Recommendation Report for Planning Permission

REF NO: M/97/21/PL

LOCATION: 76-78 Flat Above
Elmer Road
Middleton-On-Sea
PO22 6EX

PROPOSAL: Retrospective application for first floor balcony. Proposed creation of 2 bedrooms within newly created roofspace, a resubmission of M/7/21/PL

Proposed West Elevation

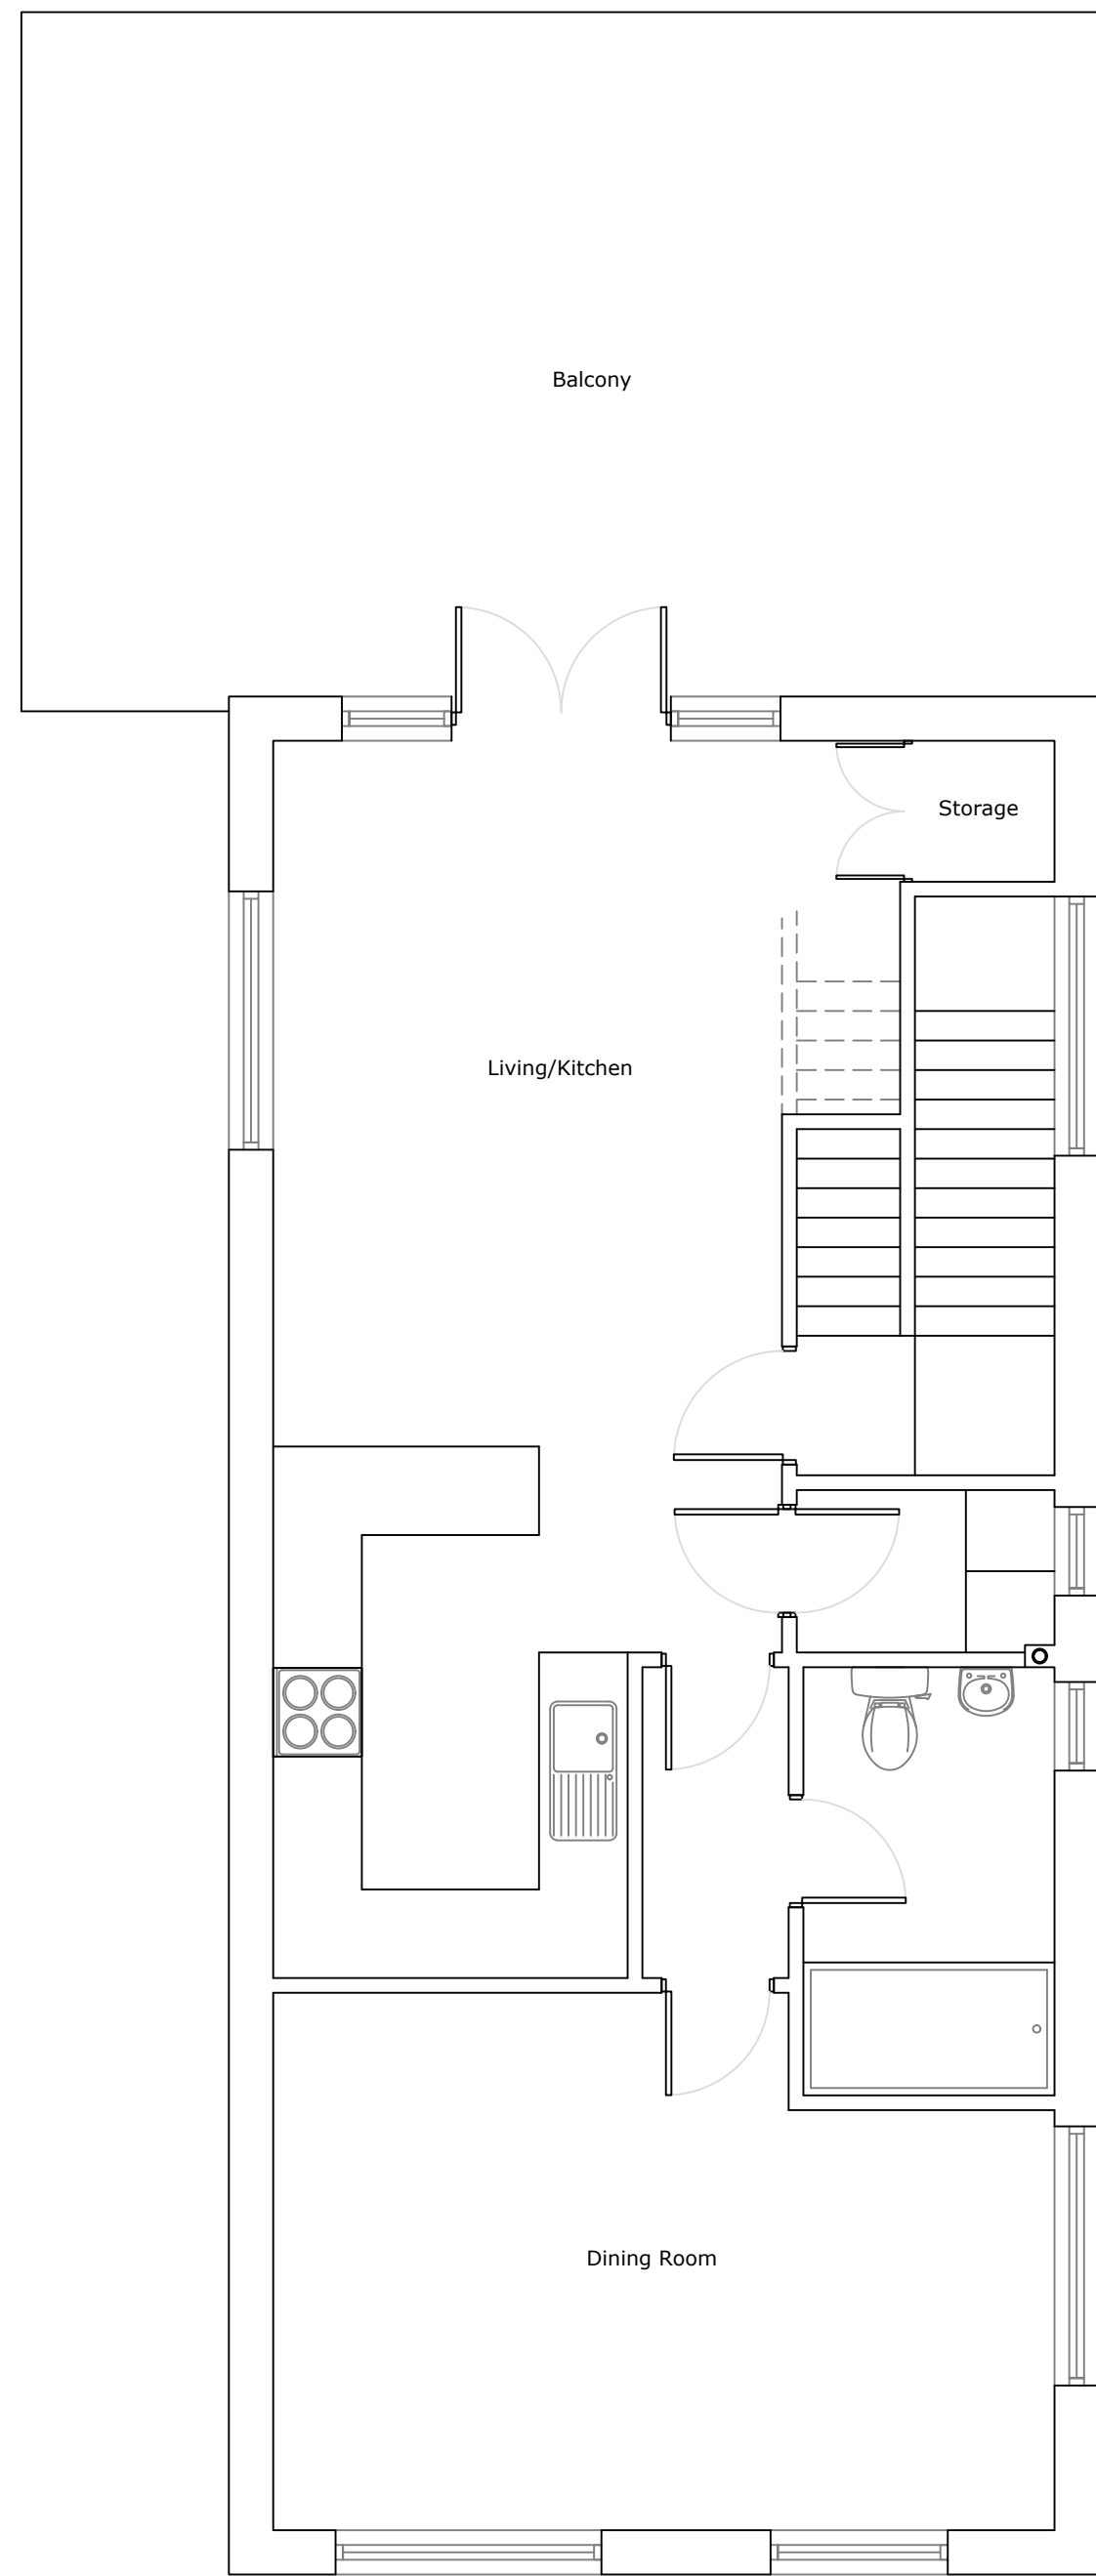
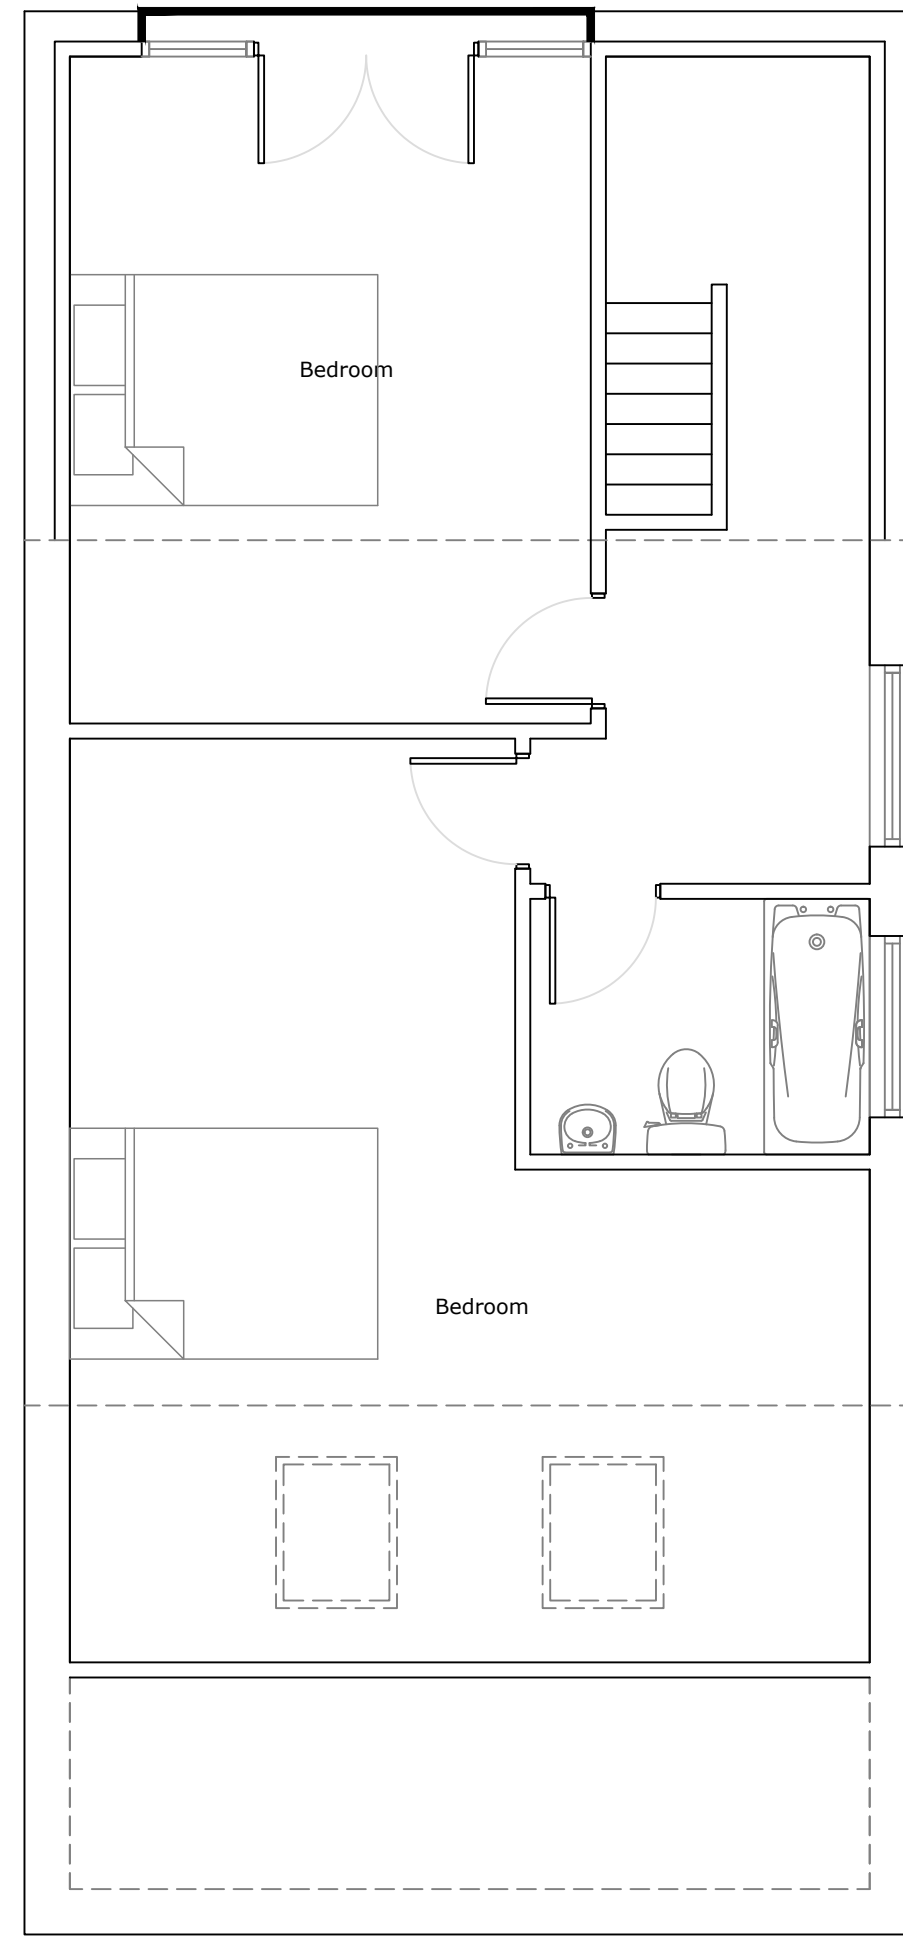
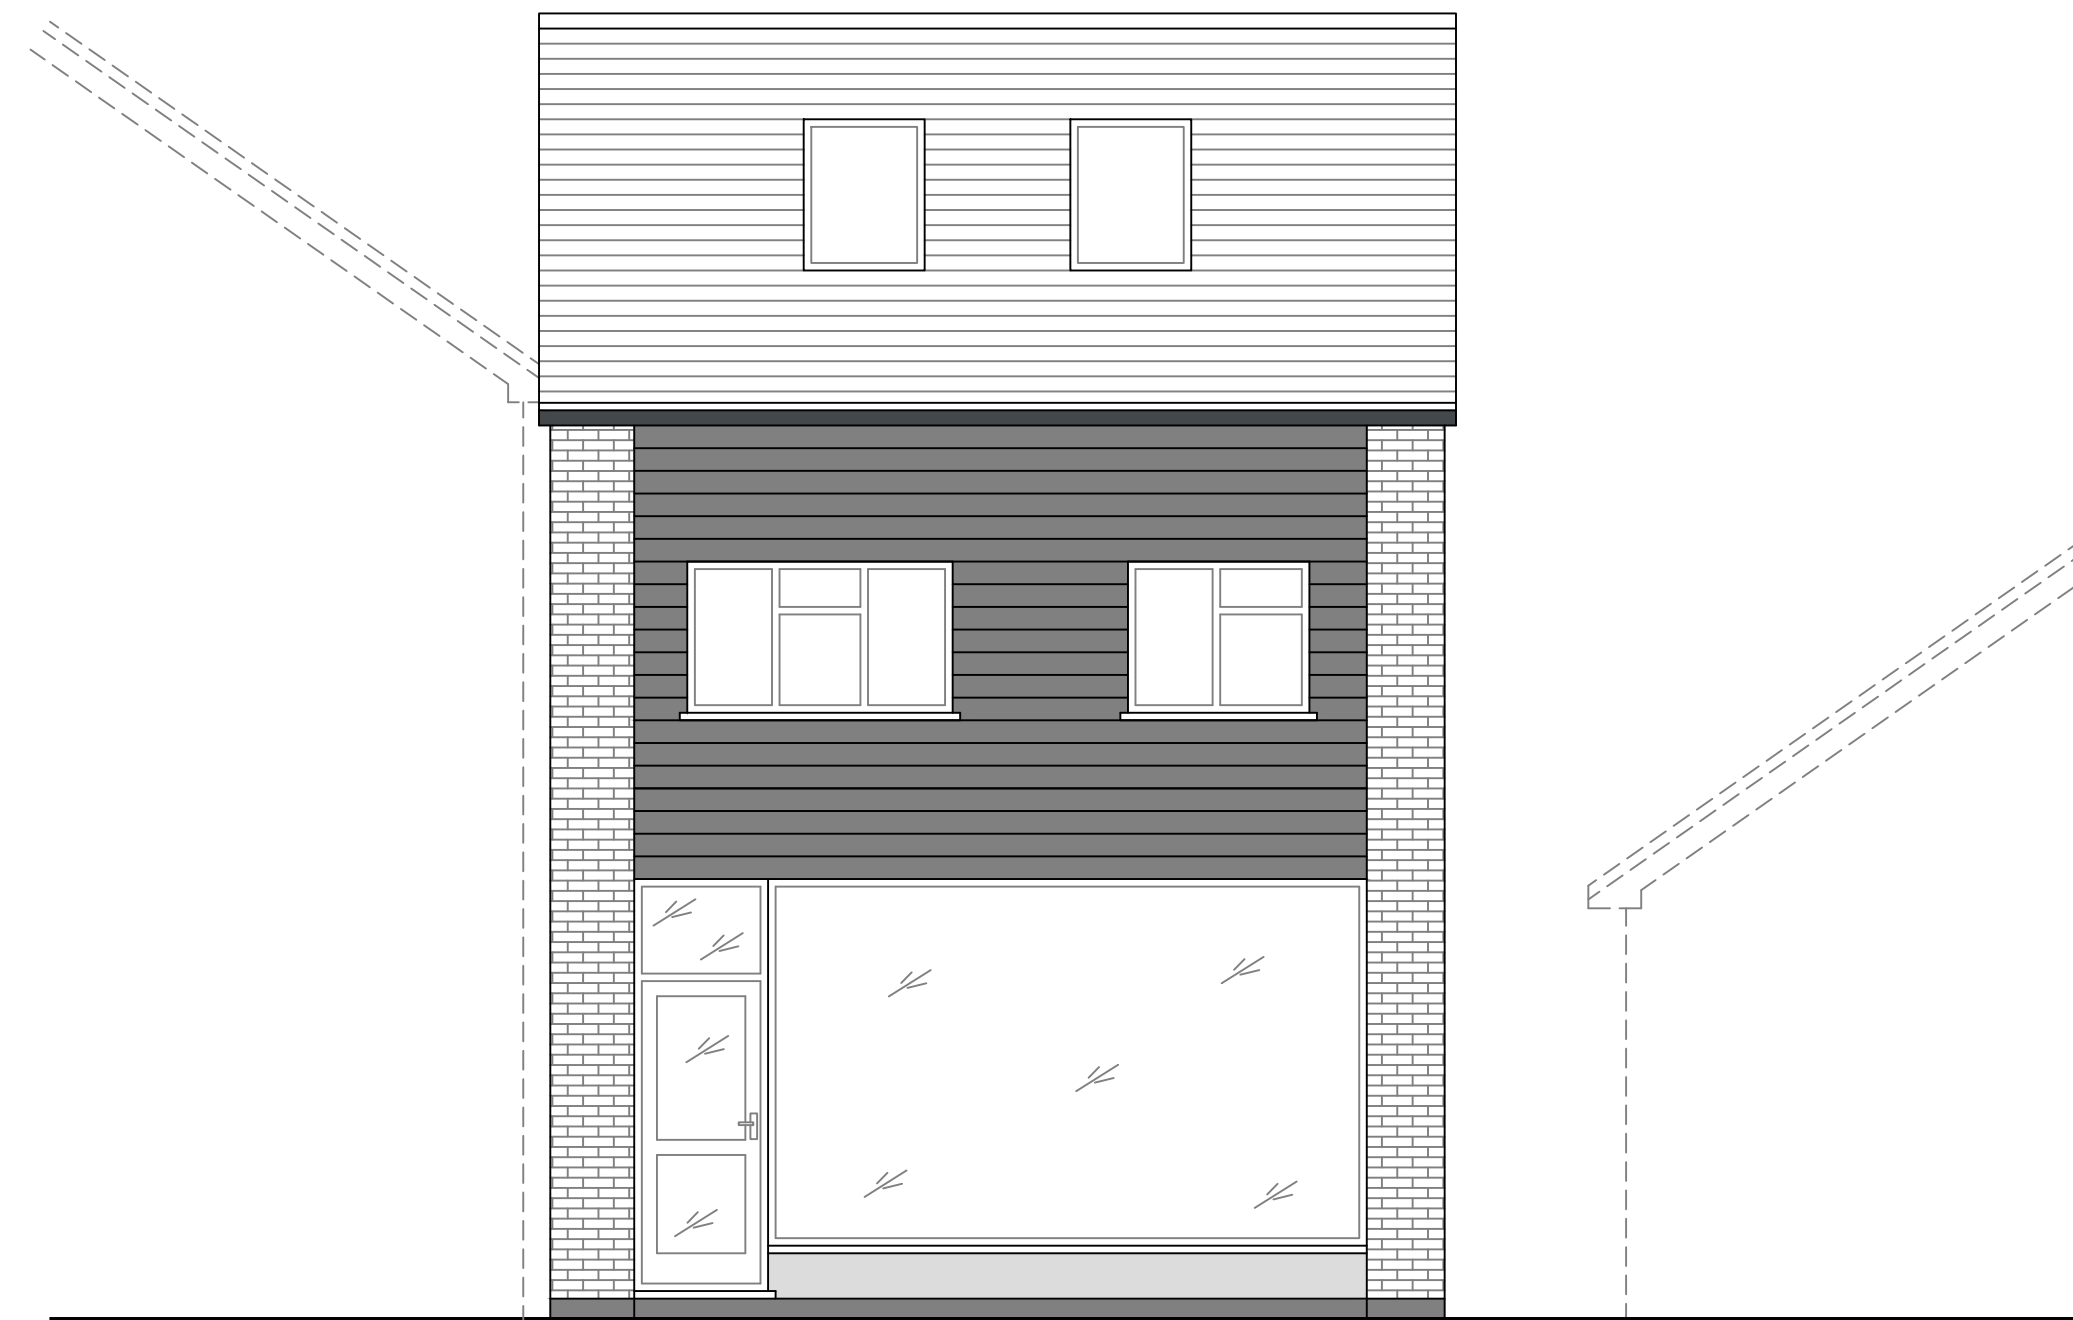
The proposal seeks to provide a new pitched/ flat roof structure to allow for an additional storey to be added onto a two-storey flat roof building. The proposal also includes a flat roof dormer with Juliet balcony to the rear (south) elevation. This proposal will provide a net increase of 1 bedroom to the existing flat.

The site currently fronts both the Elmer Road and the head of Shaw Close, and is visible from both street scenes. There are currently concerns from residents stating that the proposal will be out of character with the area and that the height of the proposal is overbearing. It was noted that the previous application was refused as it was deemed out of character for the area. The current design has eliminated two pitched roof dormers from the front elevation of the building leaving just a pitched roof plane running upwards towards the centre of site, with a flat roof section to the centre. Although it is noted that there are various roof configurations in the area, none are like the proposed specially on the east side of Elmer Road. From the front the mansard styled roof would not be noticeable, however views of this roof configuration would be visible from the west especially as the roof of the chalet bungalow of no.74 would be significantly lower. The mansard style roof would be incongruent within the street scene.

Additionally, its height is comparable with the new development of two storey properties immediately to the east. However the application site sits adjacent to a chalet bungalow to its western side, even in its existing state the existing property is higher than the property to the west. With the proposed increase in height it will be significantly taller and as such will appear out of character with its immediate neighbour at no. 74 Elmer Road.

The introduction of a pitched roof and a tile hung dormer to the rear is not considered to be overbearing on the building itself. No development will take place outside of the property's external footprint and from the primary elevation the bulk of the roof disappears towards the centre of site. From the rear the dormer

is set well back from the external ground floor footprint.

In terms of overlooking, the first-floor balcony incorporating 1.7m high obscure glazing on the 2 sides and rear, mitigating any overlooking is acceptable. However, in reality what has been erected on site is 1.7 m high obscure glazing on the 2 sides of the balcony (which is acceptable) and a much lower rear obscure glazing which has an unacceptable impact on residential amenities to the rear properties by overlooking. This arrangement is not part of the application and the issue of the height of the rear obscure glazing will be referred to enforcement to pursue formal action.

The high level Juliet balcony to the proposed second storey, due to its height and position will only provide oblique downward views, and therefore will not create unacceptable overlooking into the residential properties to the rear. This arrangement is therefore acceptable.
